Comments on the Applicant's Response to Deadline 3 Submissions [Part 9 - Noise] by William David Moore

Introduction

NMP3

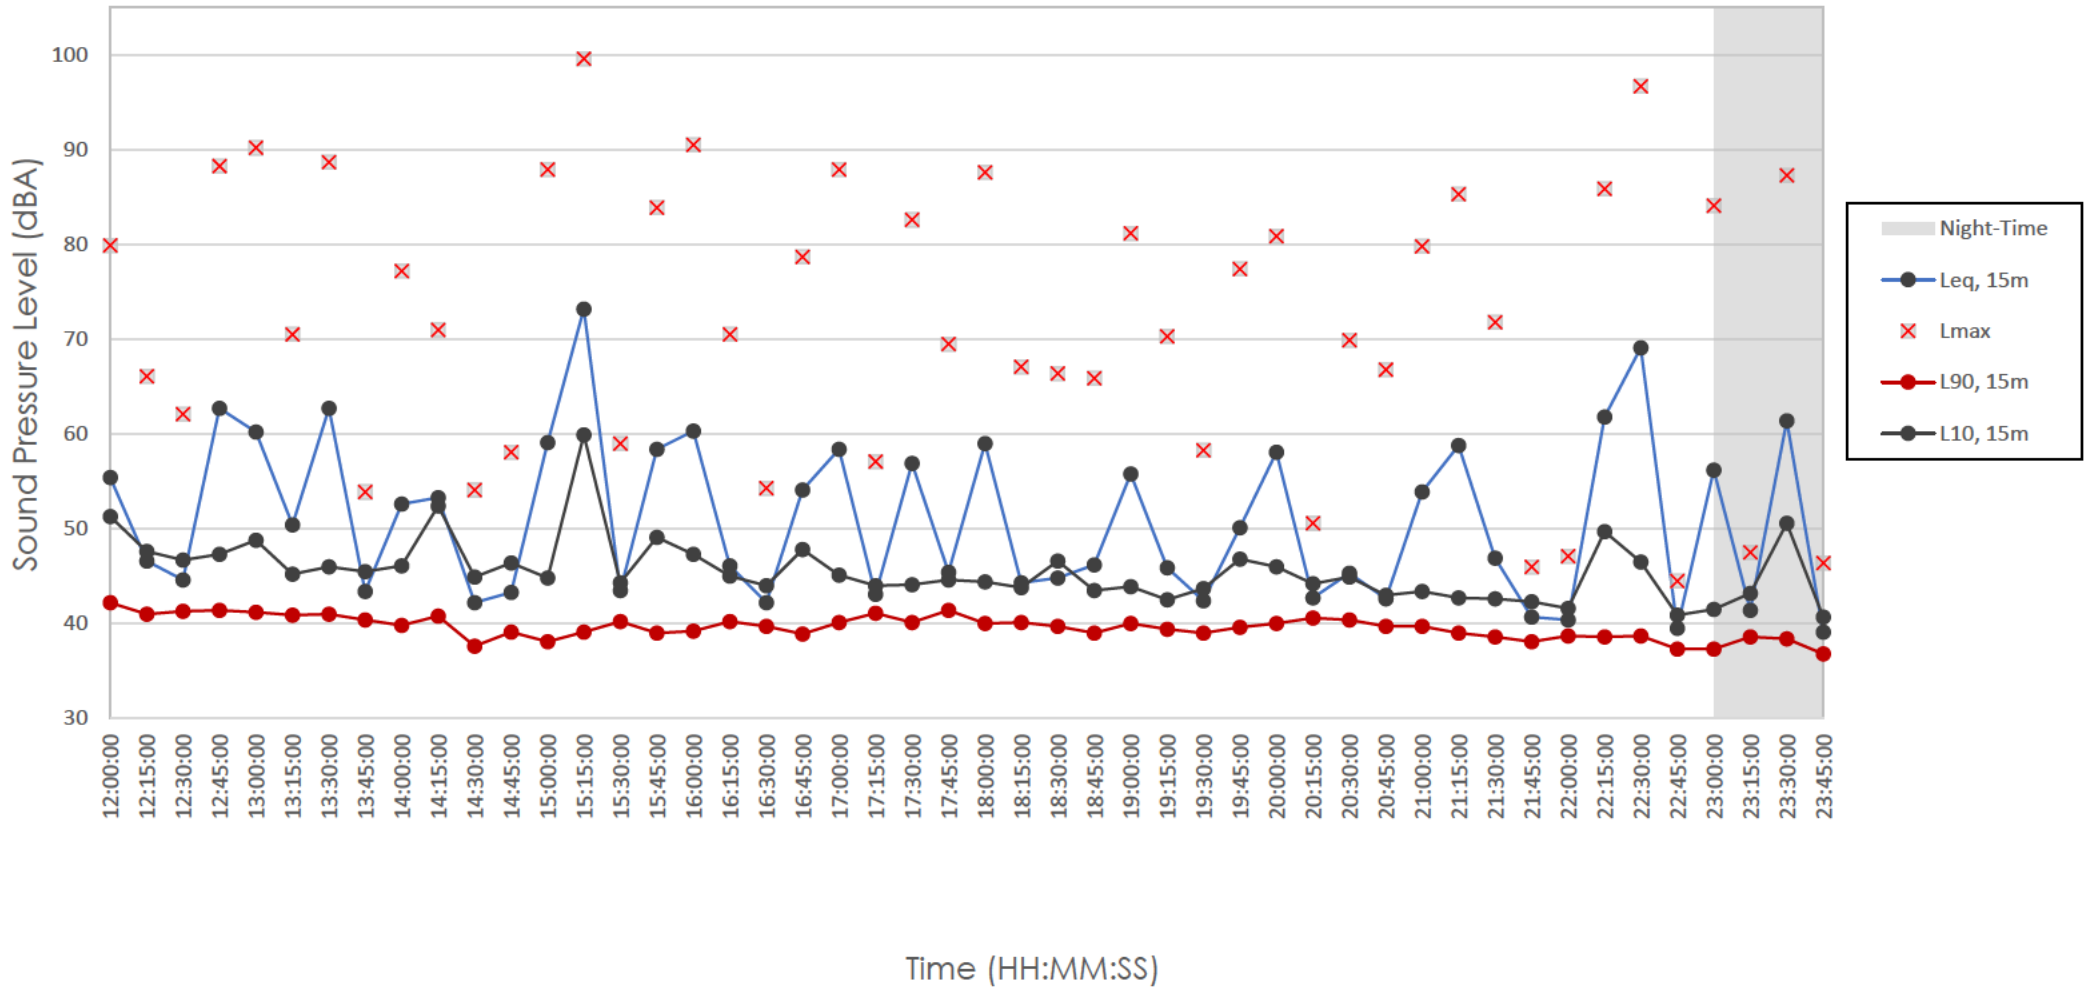
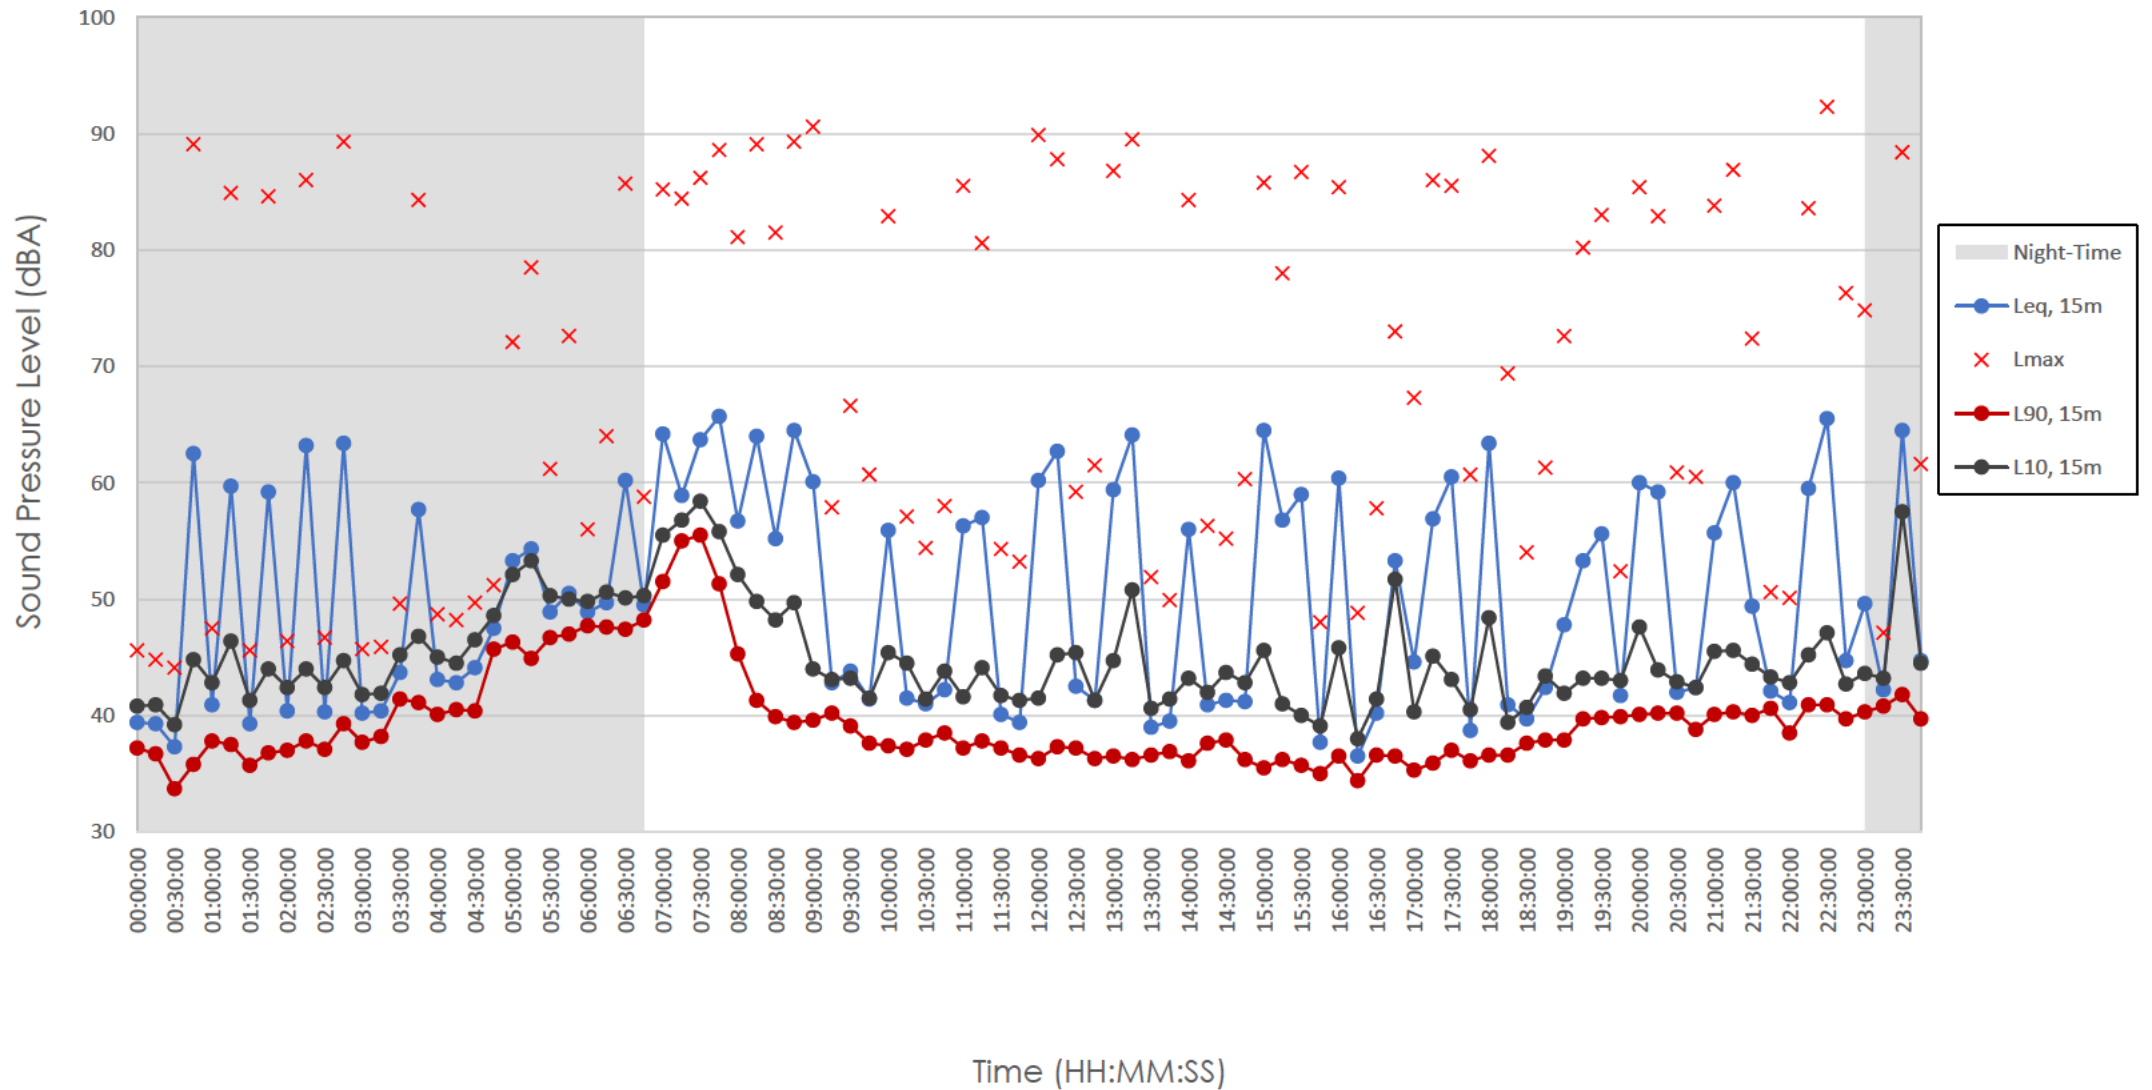
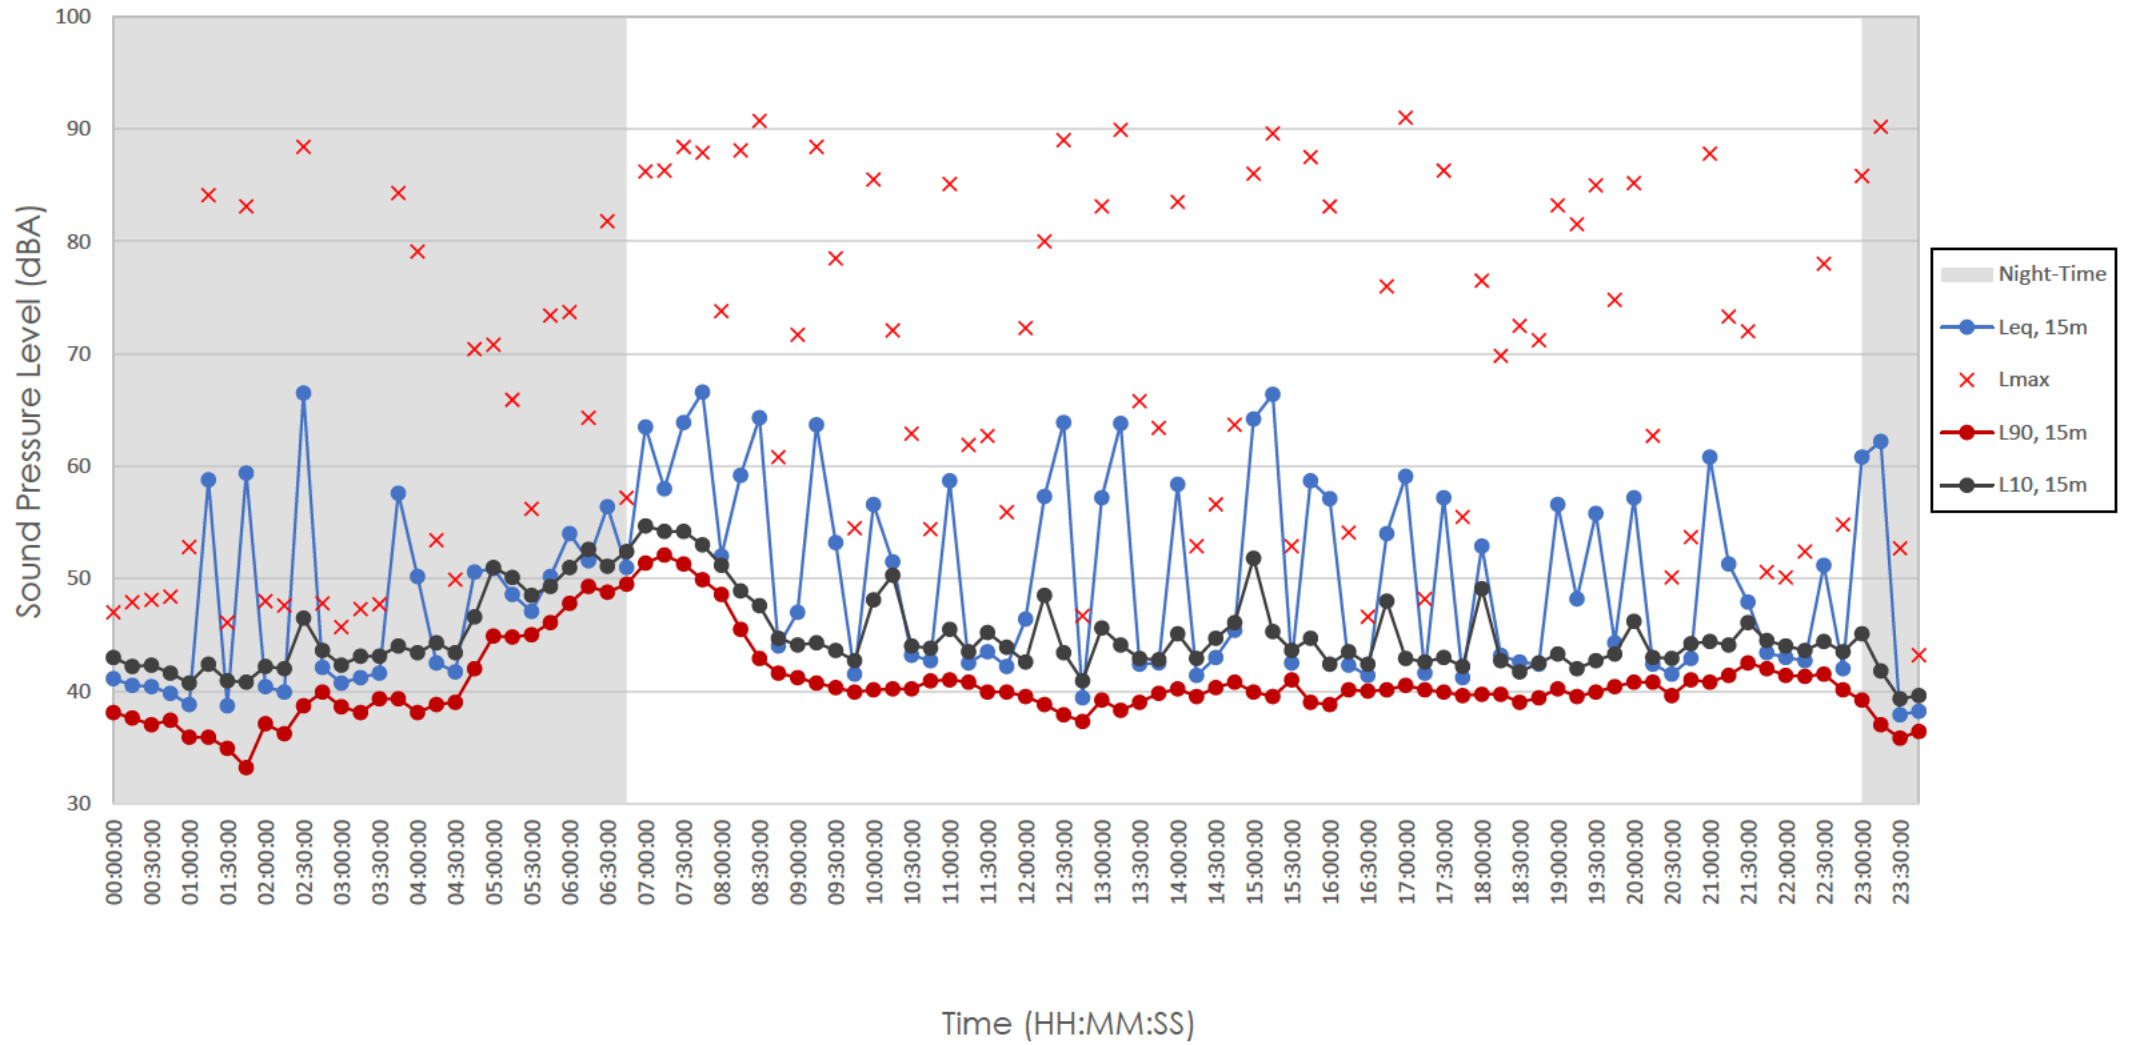
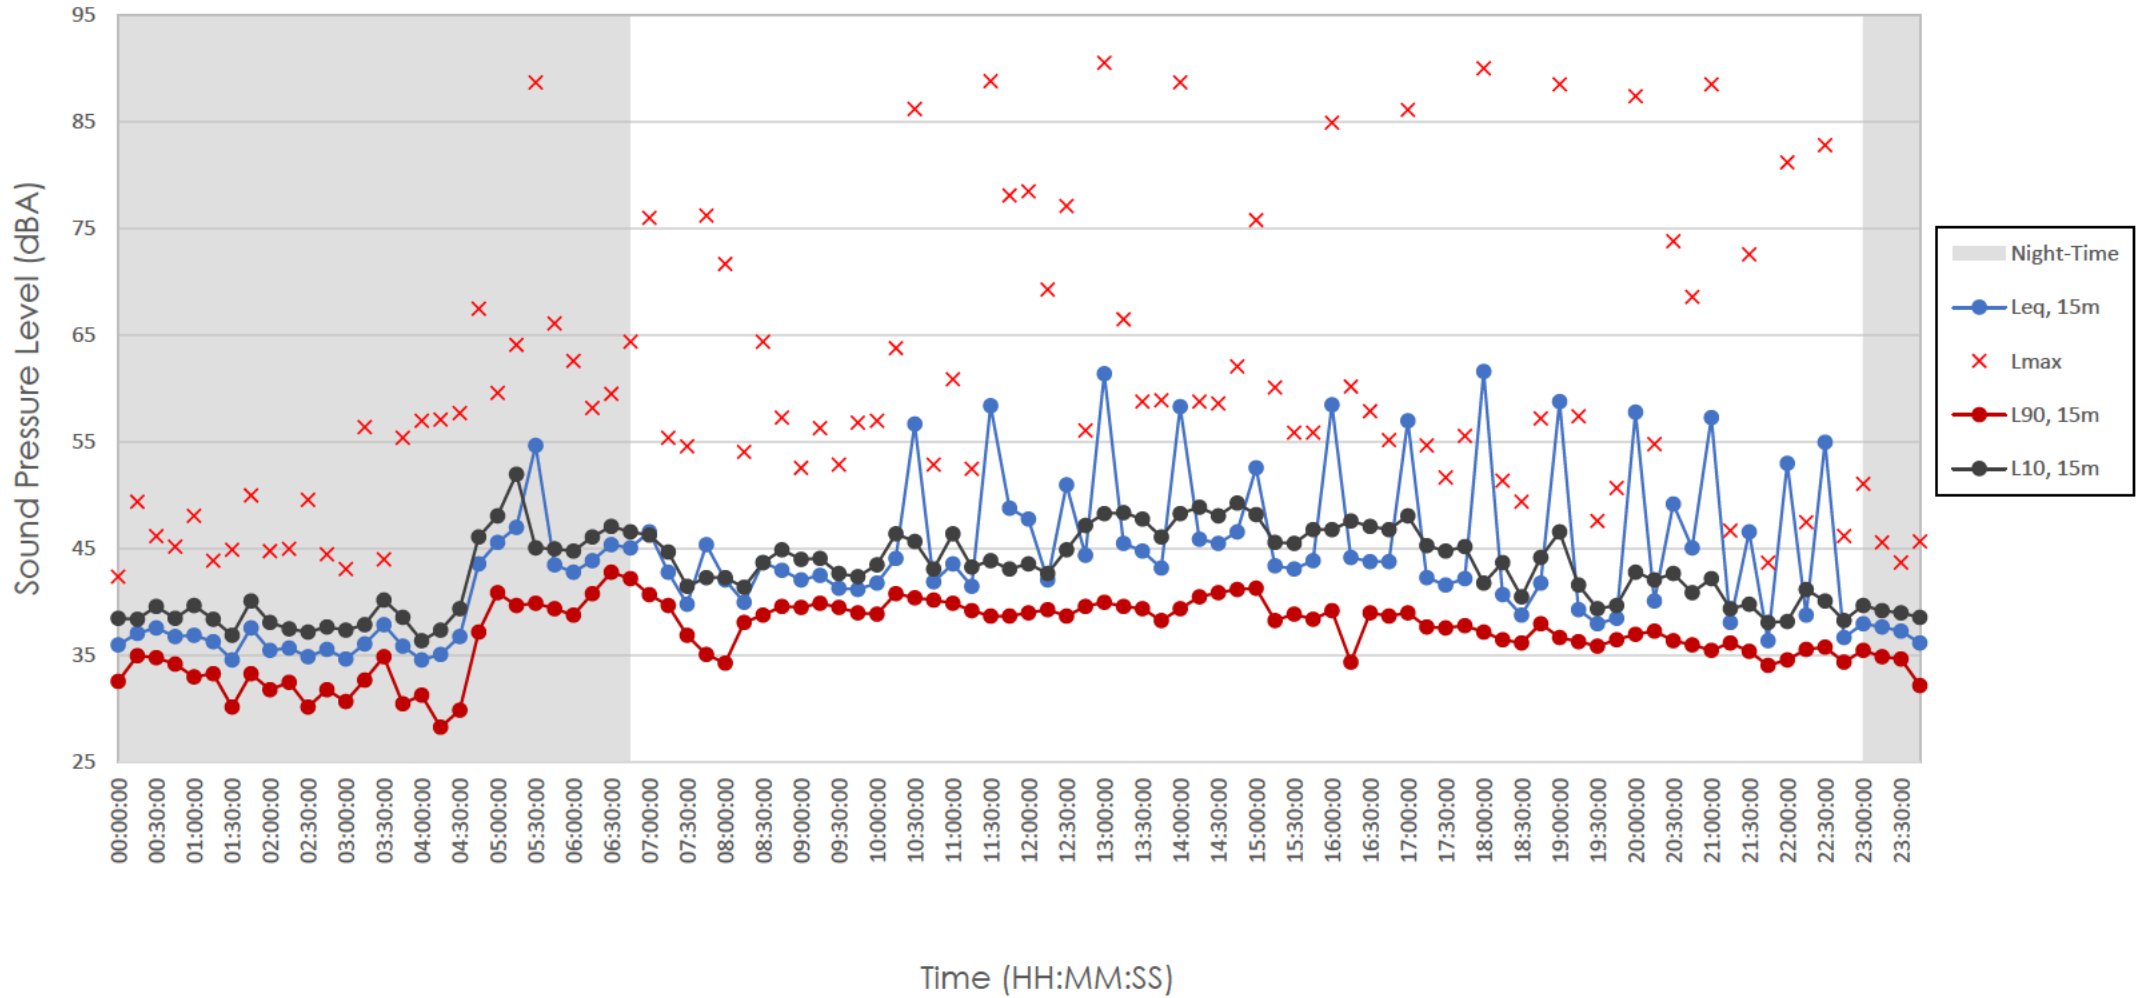
The applicant is retreating to strategic contours. We have levels measured on the ground at the site: The measurements of NMP3 & NMP4. Both of those NMPs show sound levels far lower than those depicted by the strategic contours which the applicant is attempting to rely on.

This section set the scene at Burbage Common & Woods, highlighting that the monitoring at NMP3 - in extremely close proximity to the railway line - contains the sound of extremely close proximity train pass bys which unsurprisingly caused large spikes in measured LAeq values during those periods when trains passed by.
